Our Ref: FG/60/22/NMA

**Section 96A of the Town & Country Planning Act 1990 (as amended)  
Town and Country Planning (Development Management Procedure) (England) Order 2015  
(as amended) - Article 10**

Non material amendment following FG/114/21/HH to reduce the size of approved double garage to 6m X 6m (single garage) and its location to move 1m closer towards the site boundary.

23 South Drive Ferring BN12 5QU

Drawing Name
Garage Plan and Elevations -
Proposed

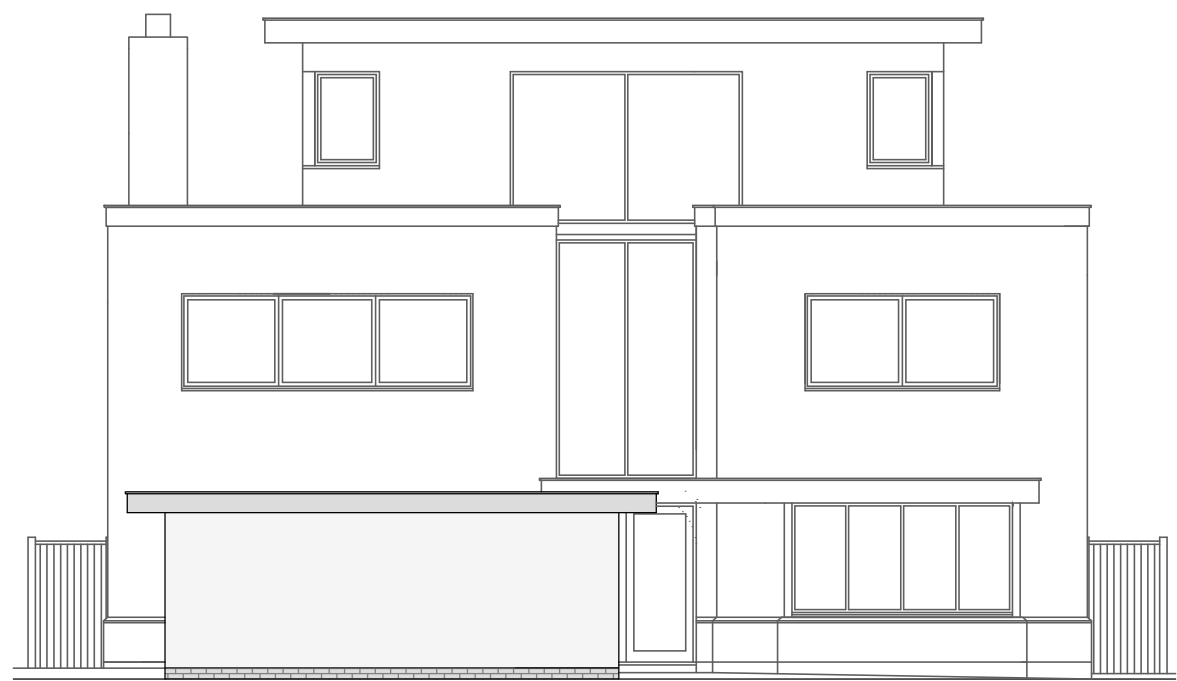
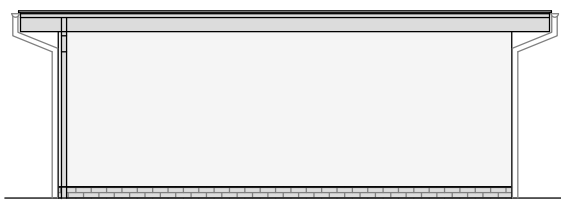
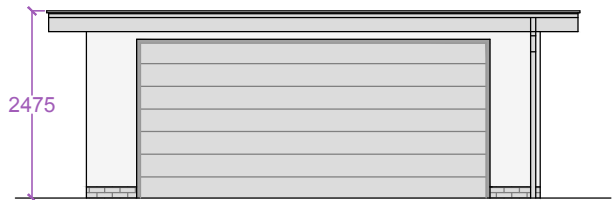
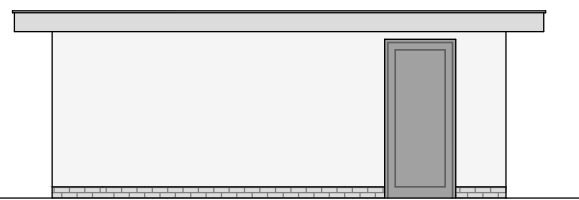
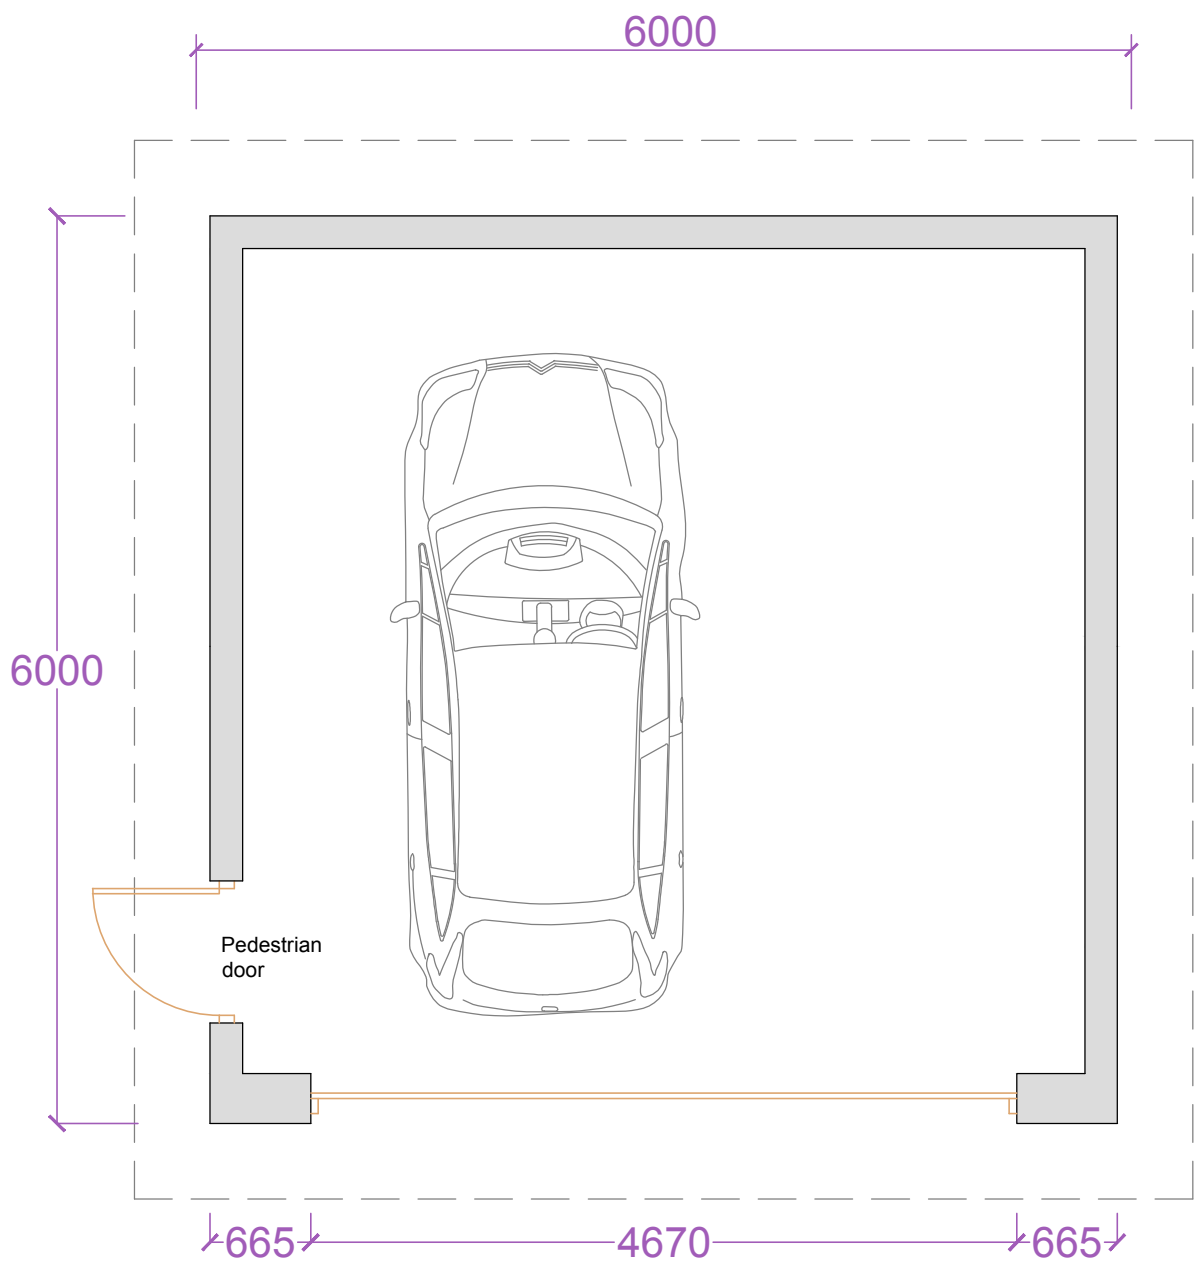
The reason that these proposals have not been accepted as Non-Material Amendments is because although there is a reduction in scale, it amends the intensity of the original planning permission and materially alters the external appearance of the proposal. It cannot therefore be considered under section 96A of the Town and Country Planning Act 1990.
